Your ref: TR050007  
My ref: DCO/TR050007/HinckleySRFI

16<sup>th</sup> February 2024

**TR050007 Hinckley SRFI – Warwickshire County Council (20040686 )  
Comments on Documents Requested to be Submitted by Deadline 6**

GIBBET LANE NB  
(HGV)

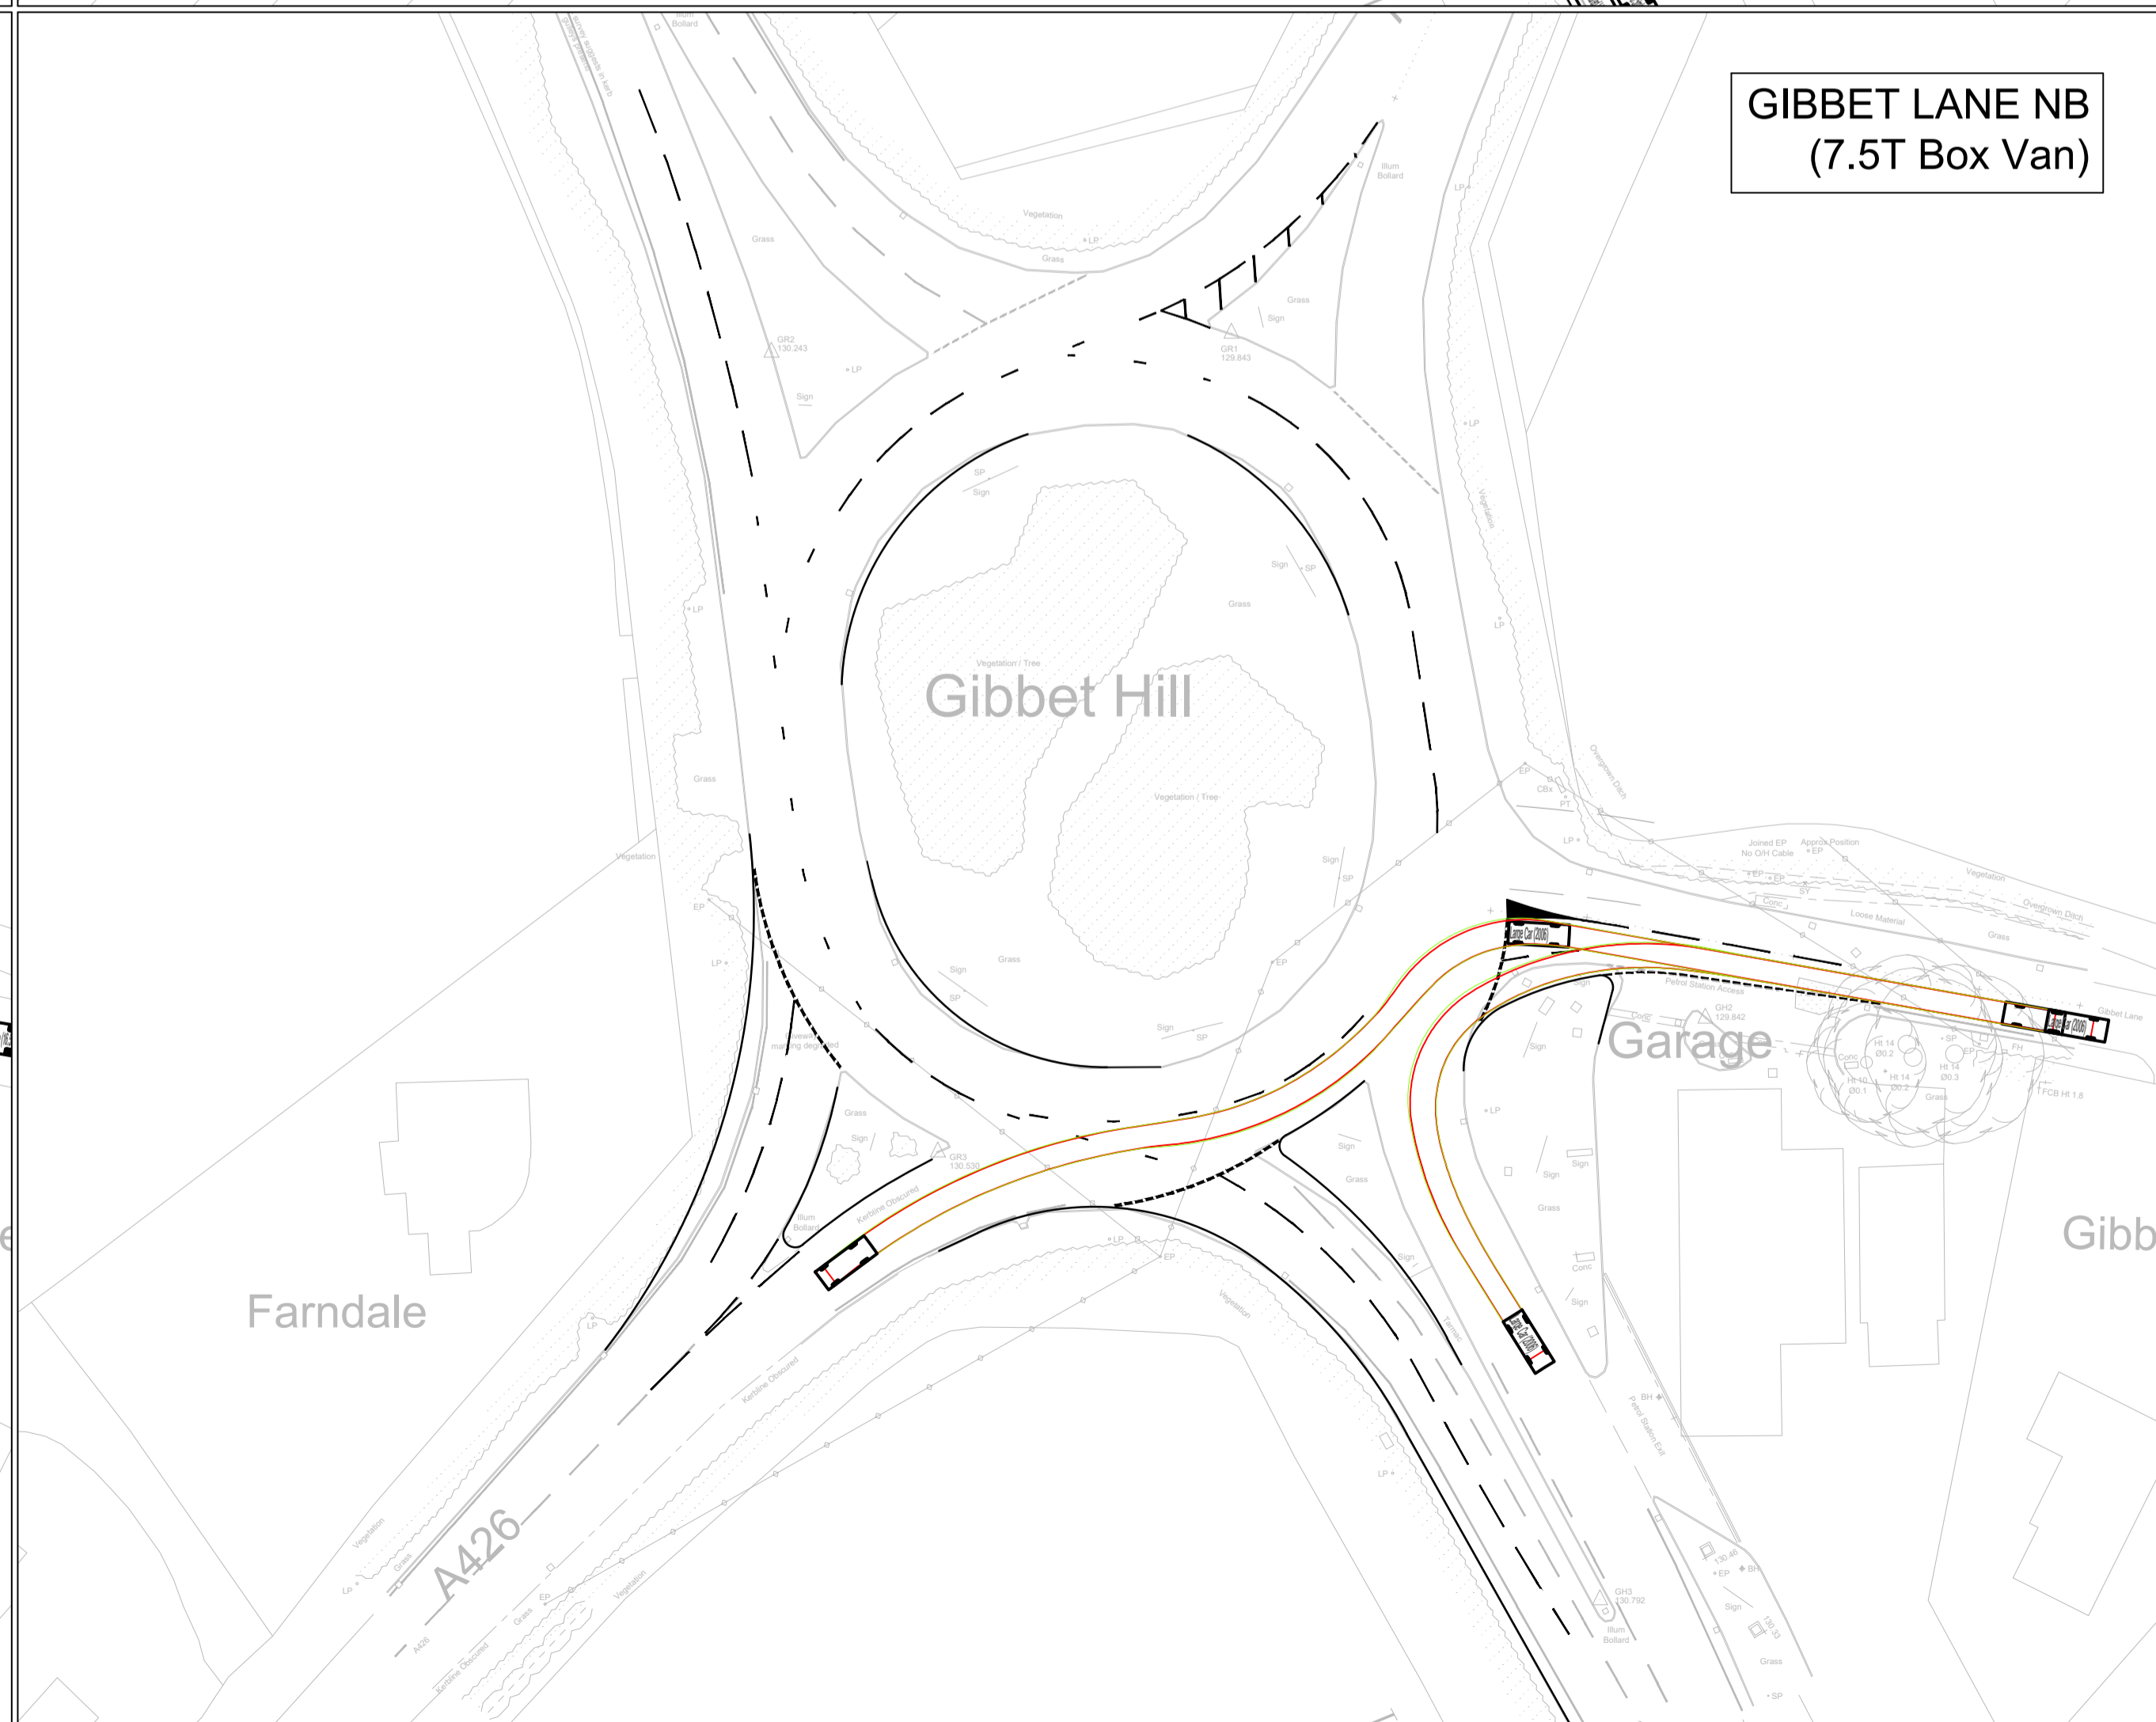
Further discussion has taken place with The Applicant and BWB over the revised turning flows following the initial furnished flows that were provided. WCC raised concerns over the level of flows forecast from Gibbet Lane in comparison to the proportion observed in the 2023 surveys. Although WCC noted that the A5 south to A426 south movement had increased, it was considered that this could be due to other committed development traffic growth, however it is understood that National Highways also raised concerns. This was set out in our Deadline 5 response.

BWB have carried out a sensitivity assessment and utilised the 2023 observed entry proportions to derive adjusted flows for the 2036 scenarios. WCC has reviewed the flows and consider that they represent a more likely pattern of flows at the junction.

Whilst the adjusted flows have been used to carry out sensitivity tests for the capacity performance at the junction using ARCADY. WCC do not consider that the 2023 scenarios adequately reflect the current junction performance in the peak hours and therefore cannot be relied upon to identify the degree of impact that the development traffic is likely to have in a 2036 scenario.

WCC still consider that the use of the VISSIM model is the best available tool to use to identify the impacts of the forecast development traffic on what is an already congested part of the network, as set out in our earlier responses.

Figure 2 – Problem Location Plan

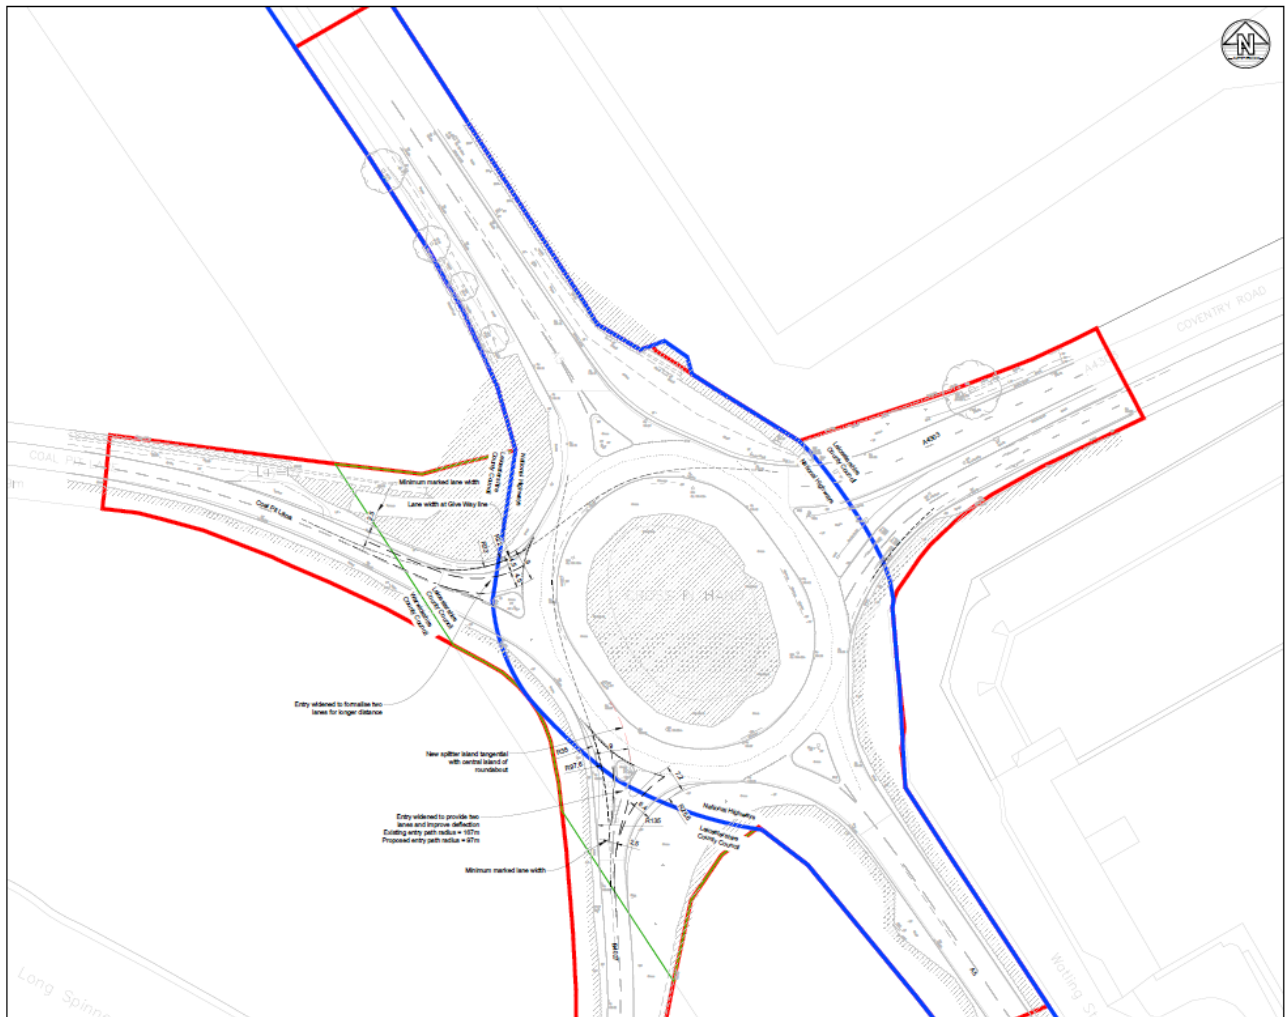
Notwithstanding this sensitivity assessment work. Additional information has been submitted by BWB in respect of the swept paths at the junction and the preliminary design of the mitigation scheme to address the problems identified within the Interim Road Safety Audit. WCC are satisfied that this additional information demonstrates the

scheme would be acceptable in principle. WCC anticipate that The Applicant will be submitting this revised information to the ExA at Deadline 6.
